## Application by Rosefield Energyfarm Limited for the Rosefield Solar Farm

The Examining Authority's second written questions and requests for information (ExQ2): issued on 5 June 2026

REV 00

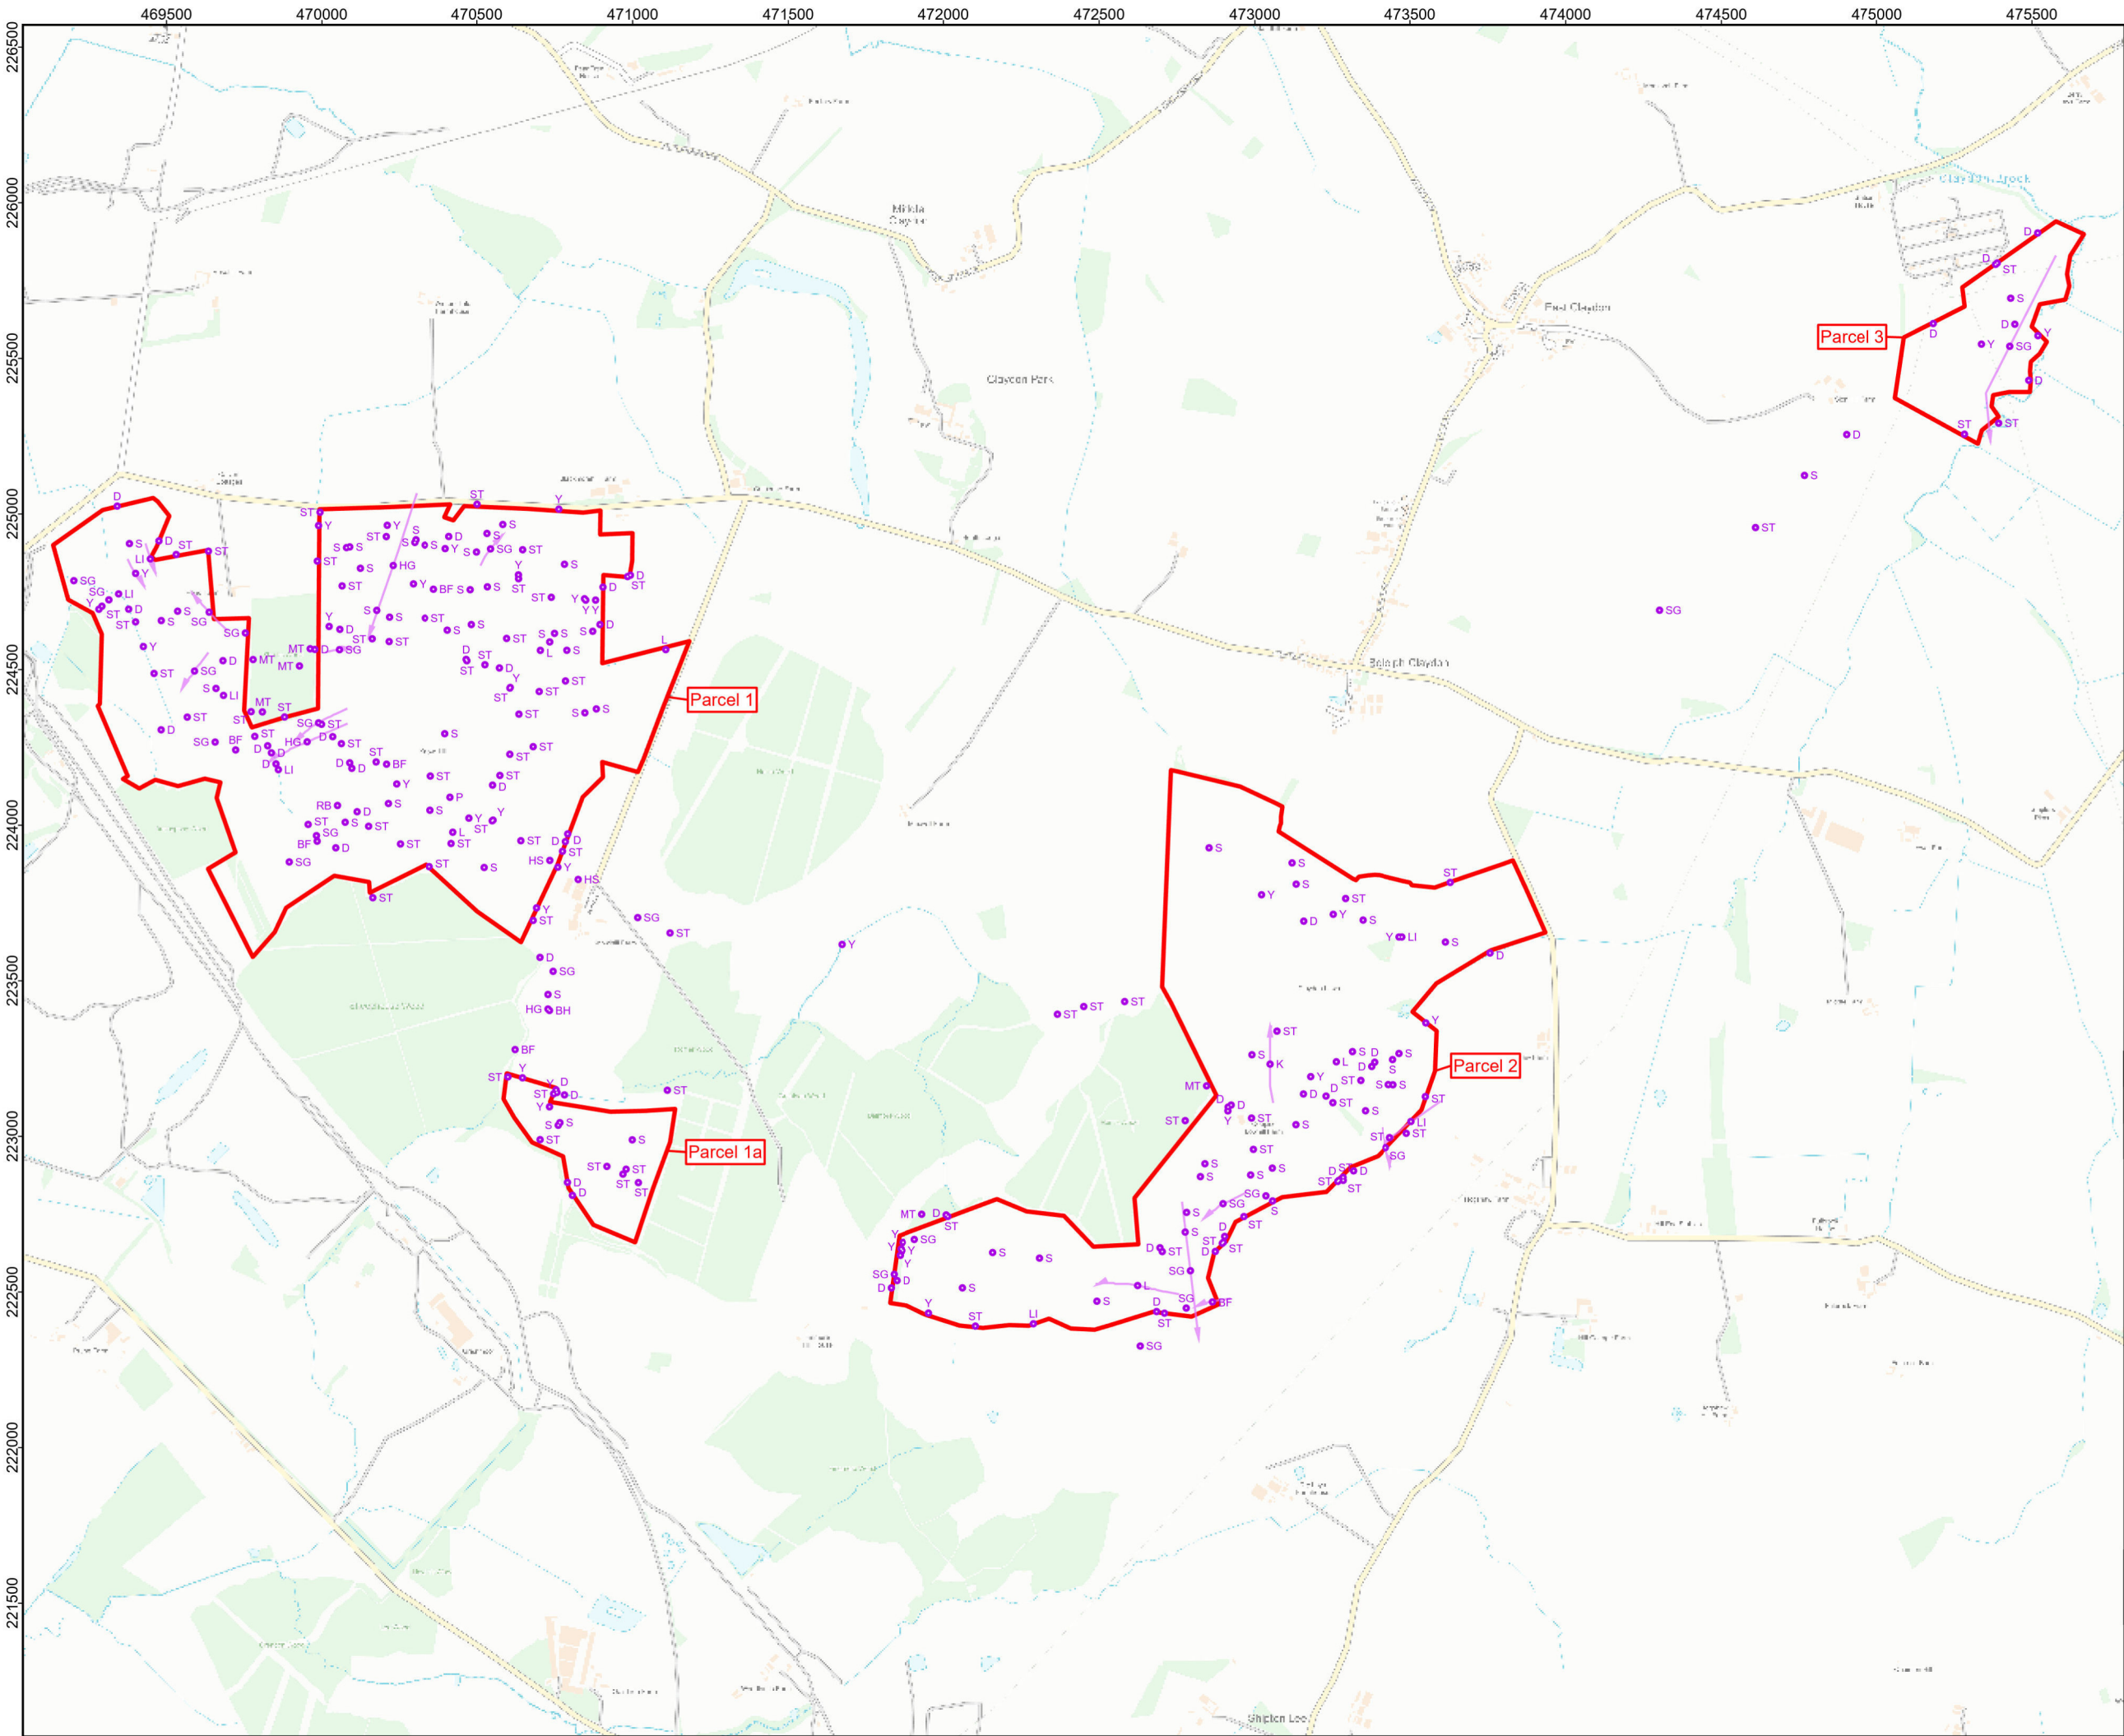
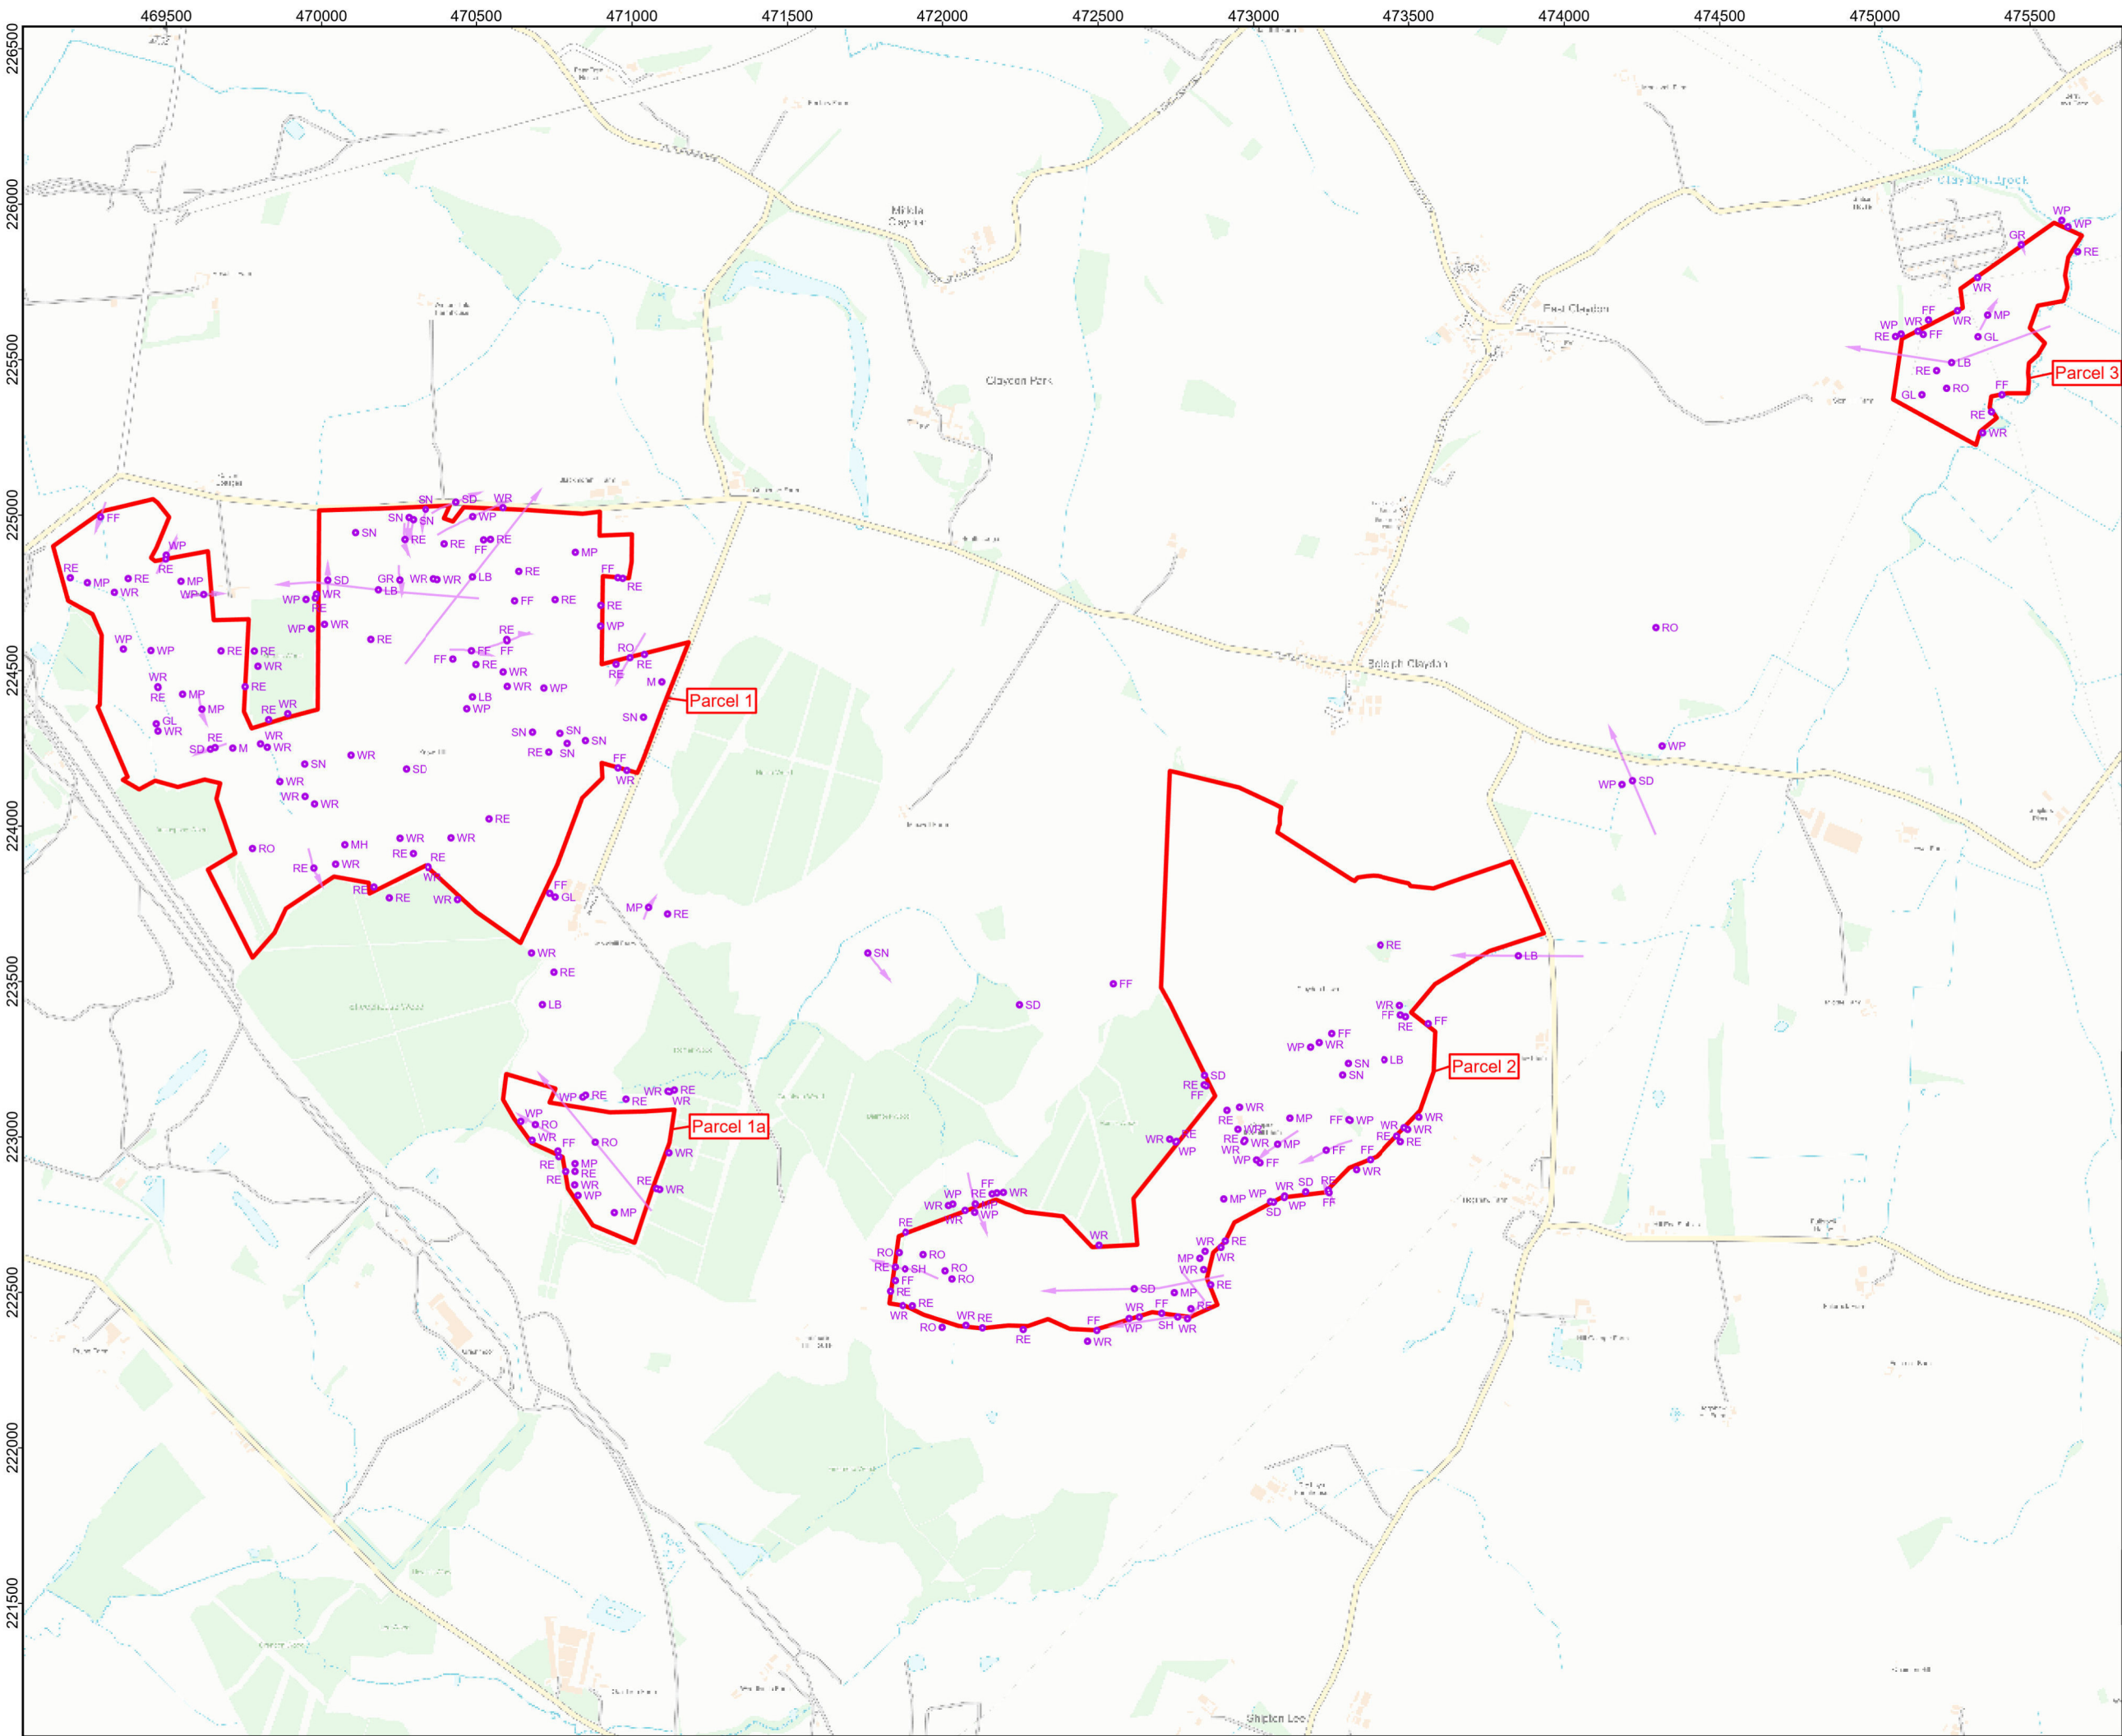
Q2.2.7	The applicant	<b>Site selection – alternatives</b> Provide further explanation for the drawing of the “site boundary” identified in the Wintering Bird Survey Report undertaken in 2022 <a href="#">[APP-089]</a> .
<b>3. Air quality</b>		
Q2.3.1	Preston Farms Limited and TCS Biosciences Limited	<b>Battery Energy Storage System (BESS) – Plume Assessment</b> Following discussions at issue specific hearing 1 (ISH1) on your critical review of the BESS Plume Assessment by a battery safety expert <a href="#">[REP2-107]</a> the applicant has updated its BESS Plume Assessment Summary <a href="#">[REP3-042]</a> and included commitment D25 in its Design Commitments <a href="#">[REP3-010]</a> “BESS containers and transformer units will be offset at least 50m from the southern boundaries of fields D8 and D9 and the eastern boundary of field D9  Has this addressed all your concerns? If not, what further action should the applicant take?
